RE: RESPONSE TO CITY OF SYDNEY COUNCIL REVISED COMMENTS ON 21ST MAY 2021

SOIL DEPTH PLAN | LANDSCAPE

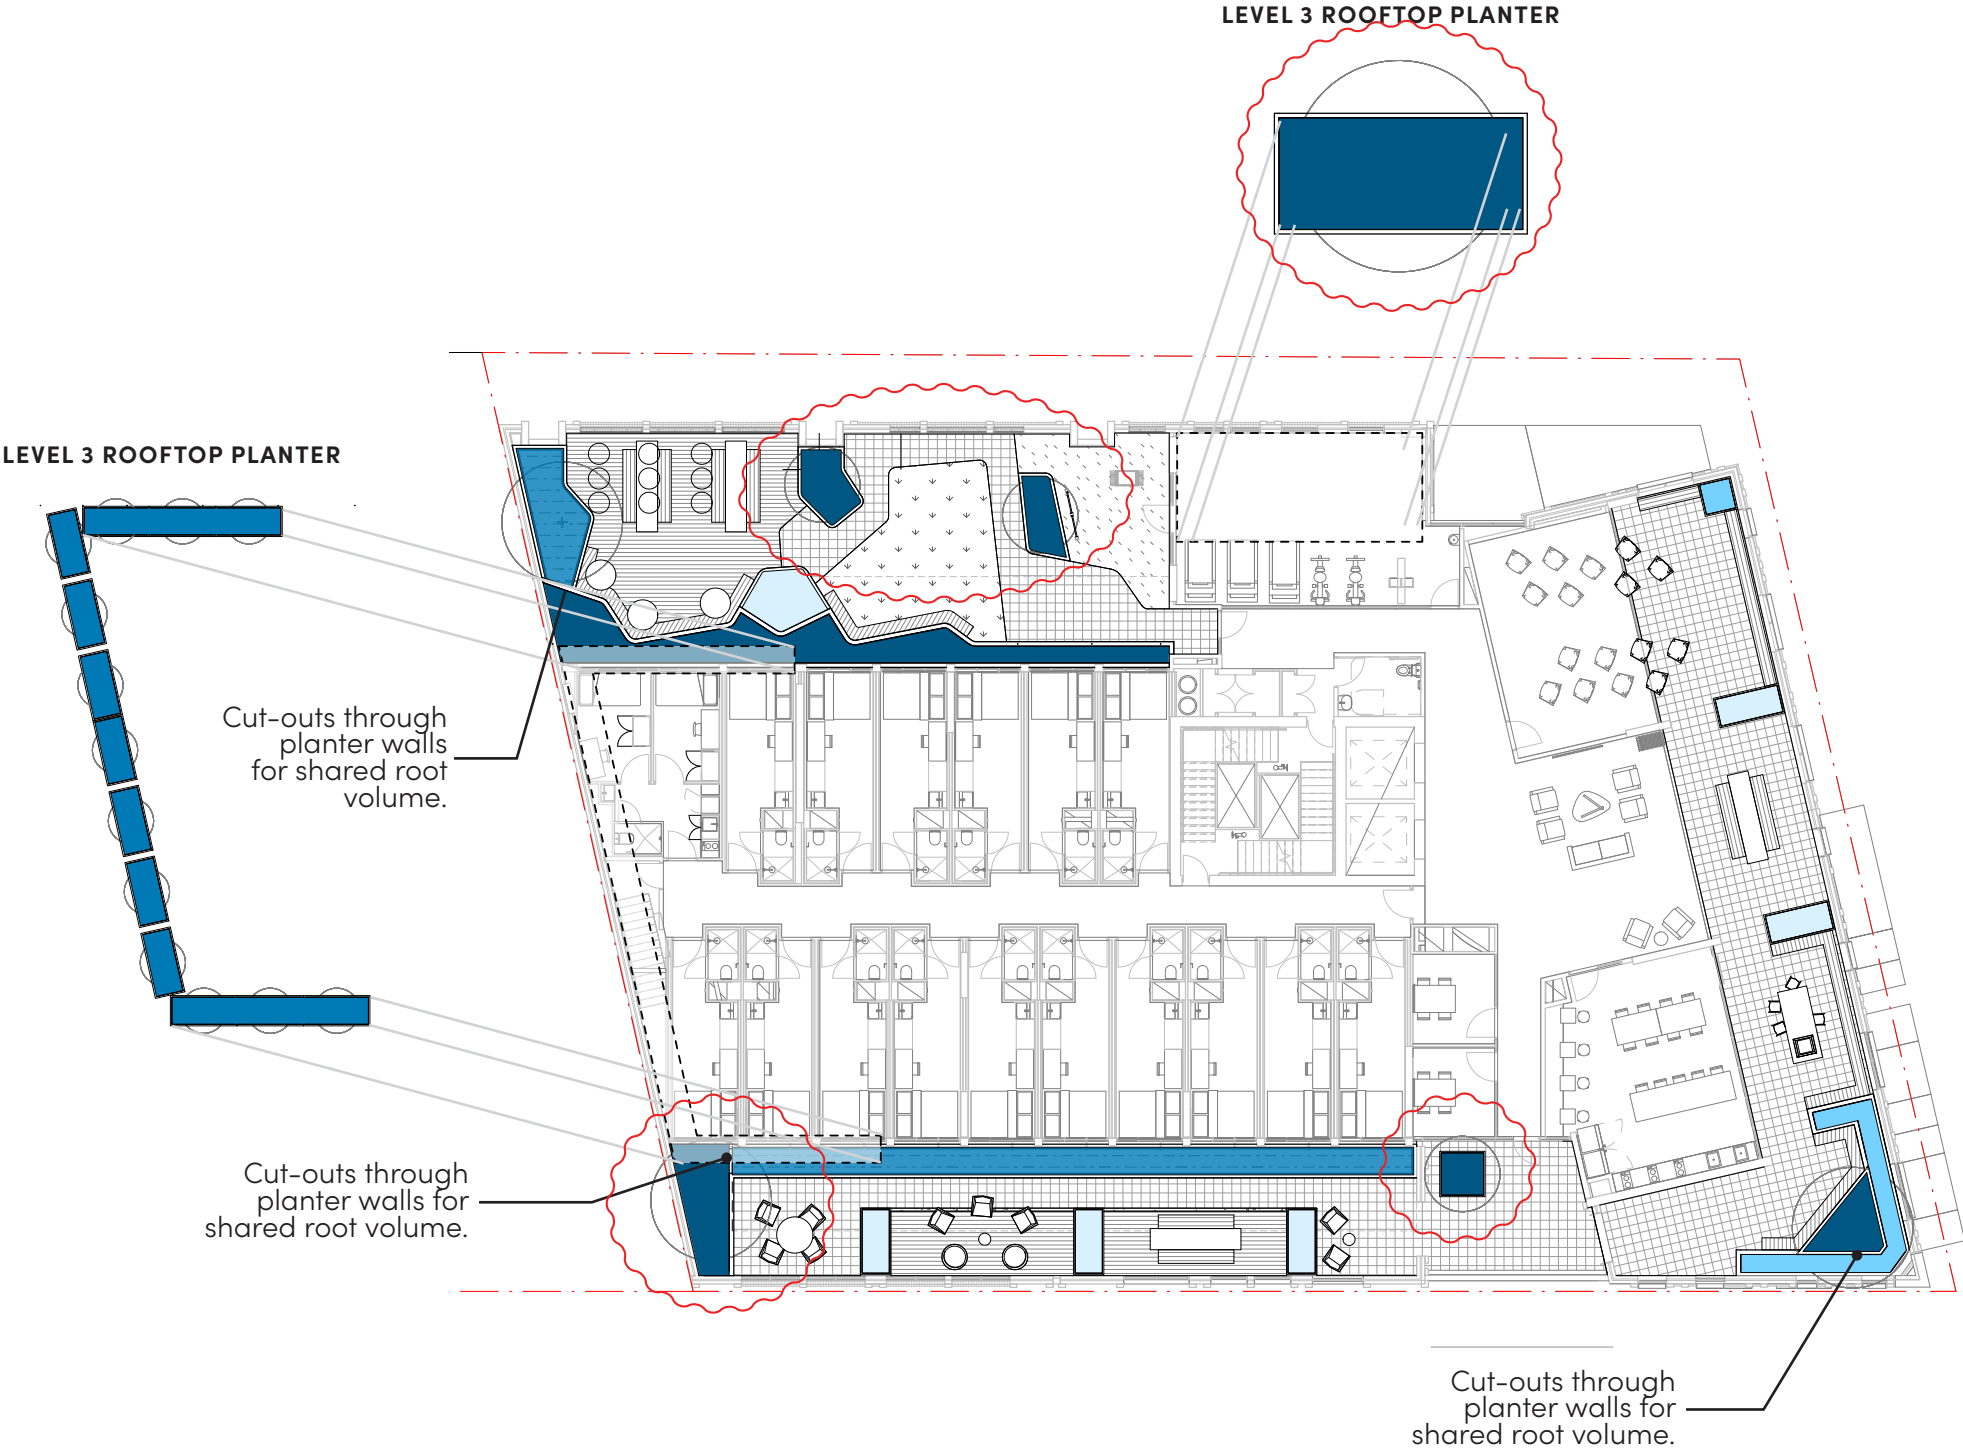
5c- The garden beds proposed on Level two are not large or deep enough to sustain trees and must be amended to provide adequate soil volumes for the planting of trees as laid out within the Sydney Landscape Code. The smaller

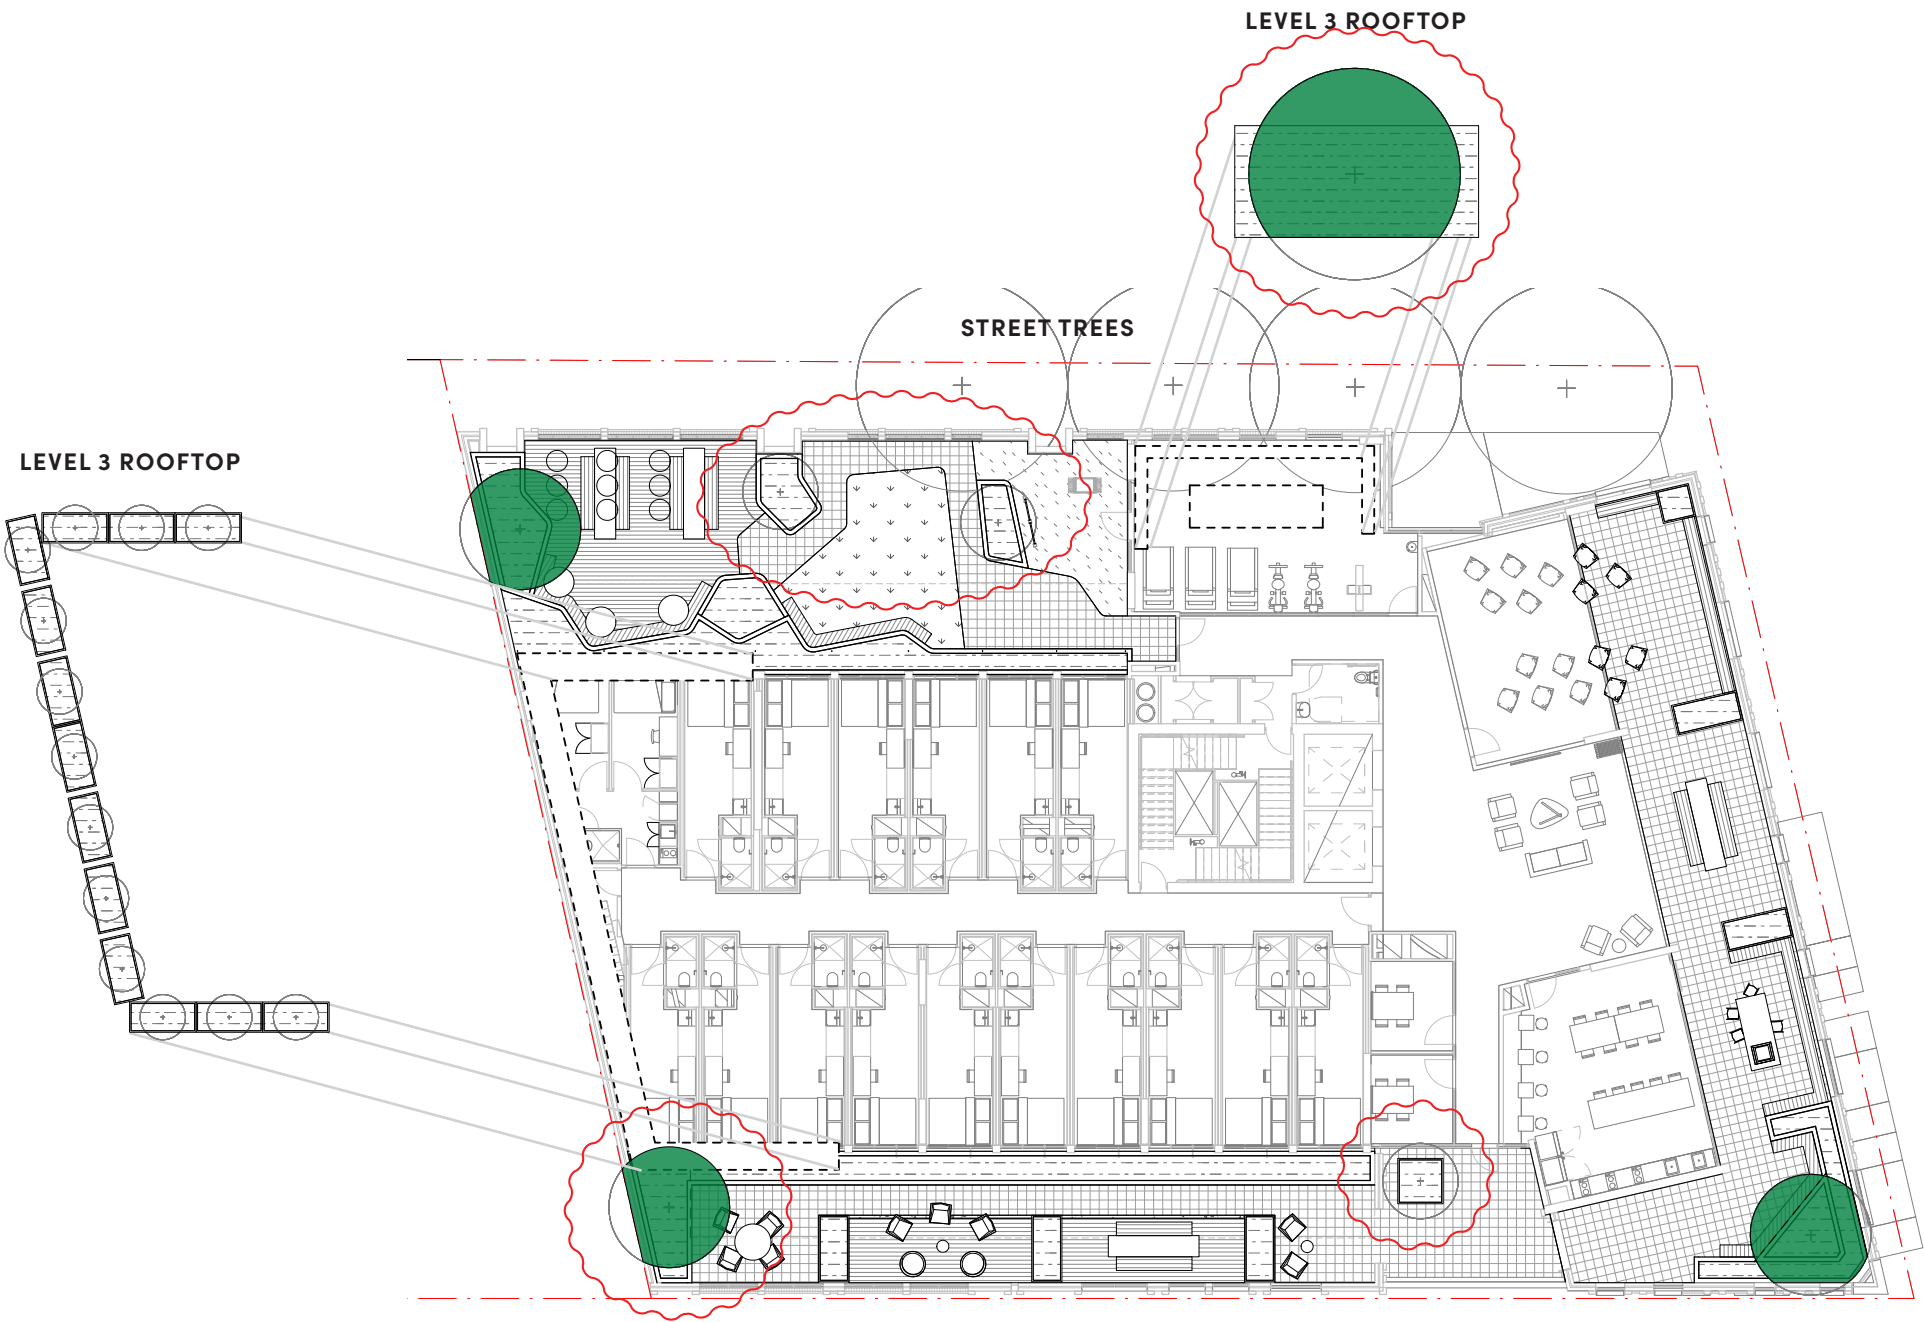
5a- The landscape plans must be amended to provide the required 15% canopy cover under the Sydney DCP 2012 controls.

The canopy coverage target of 15% is not feasible within the current design. Please refer to the planner's comments for details.

While it was not possible to provide for the establishment of canopy trees on the Level 2 terraces, the proposed landscape treatment maintains a biophilic connection through an array of raised planters for small trees, vines and potted plant specimens. Substantial vertical greening is provided through generous vine planting on all terraces, enhancing the richness of the landscape. Break out spaces are provided for residents to enjoy the outdoor landscape via small and large group seating and alfresco dining areas, in addition to exercise and movie watching spaces. Appropriate planting provides for visual privacy between the student rooms and the adjoining communal spaces on the eastern and western terraces. The updated drawing set prepared by Turf Design shows an amended tree canopy coverage plan and corresponding set of calculations in response to council's comments.
